Consultation Response from KC, Conservation and Design		
2020/90705 11, Queens Road, Edgerton, Huddersfield, HD2 2AE		
Erection of detached garage and alterations to boundary wall (within a Conservation Area)		
Date Responded: 08/04/20	Responding Officer: Craig McHugh	Responding Ref: Edgerton

Revised following receipt of revised plans

Proposed Garage and Alterations to Boundary Wall at 11 Queen's Road Huddersfield

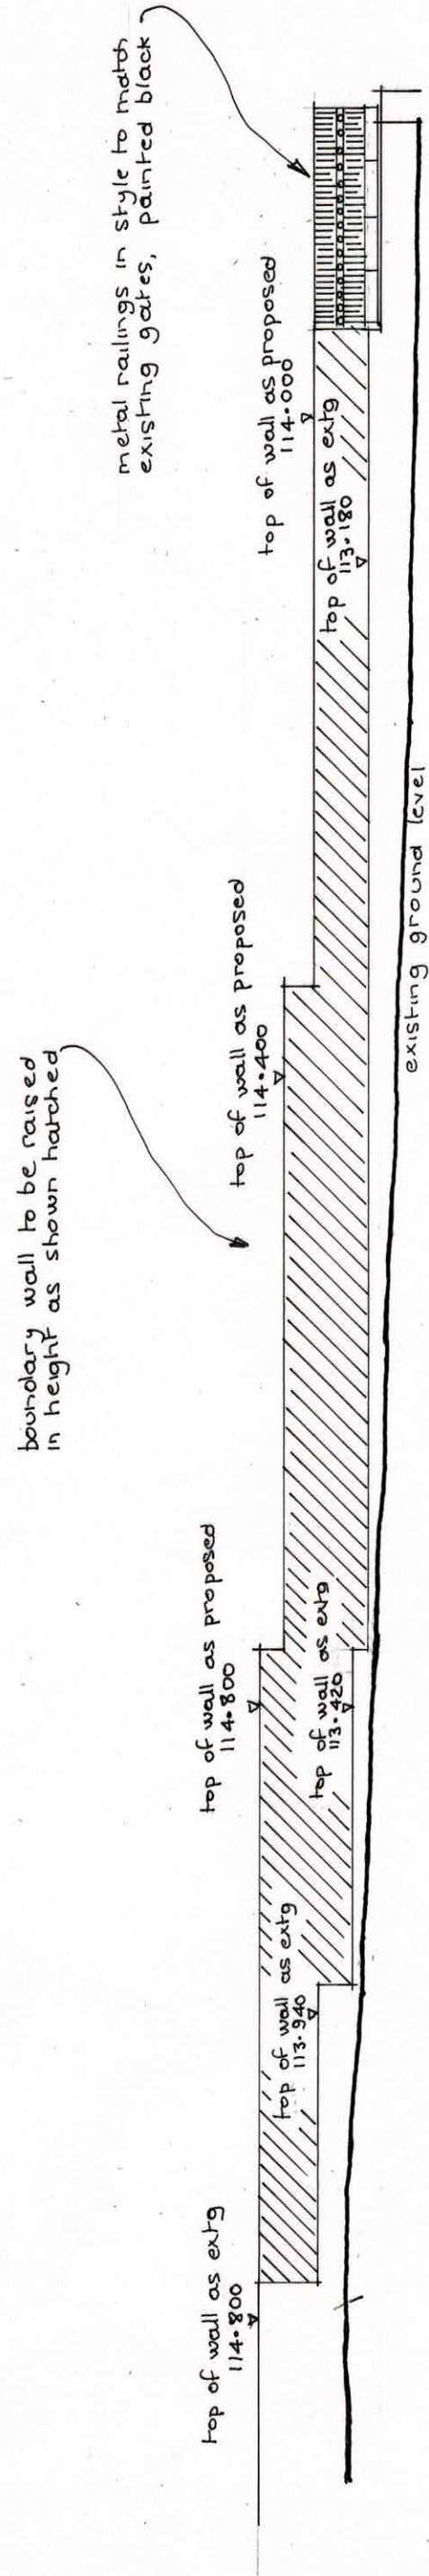
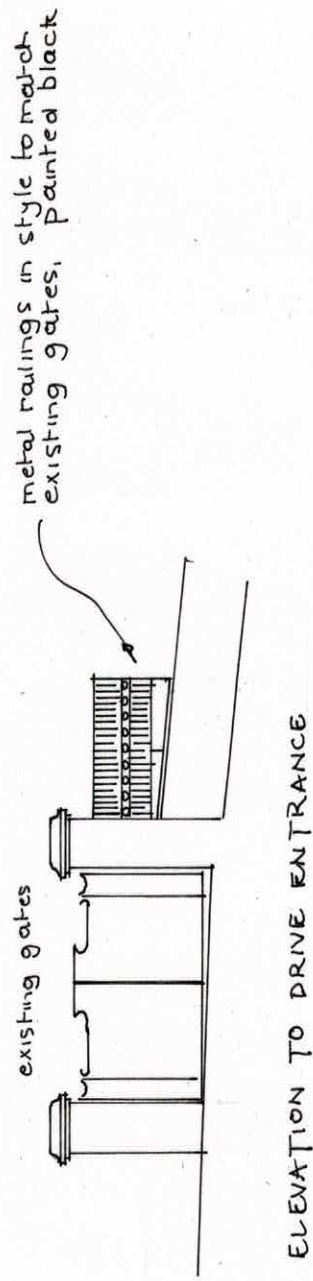
There is no concern about the proposed alterations to the boundary wall adjoining no.12 Queens Road and the addition of railings to the top of the wall.

The proposed development would result in the loss of an area of landscaped garden to the front of the property and the insertion of a new garage awkwardly juxtaposed with the existing house and its extension. This would cause some harm to the character and appearance of the conservation area. That harm would be less than substantial harm.

Conservation and Design have concerns about the proposed development on heritage and design grounds particularly with regards to Section 72(1) of the Planning (Listed Buildings and Conservation Areas) Act 1990, Policies LP24 and LP35 of the Local Plan and Paragraphs 193, 194 and 196 of the NPPF. The loss of garden, the siting of the development and its awkward juxtaposition with the existing

house and extension would cause harm to the character of the conservation area. Great weight should be given to its conservation. Clear and convincing justification should be sought for that harm and it should be weighed against any public benefits.
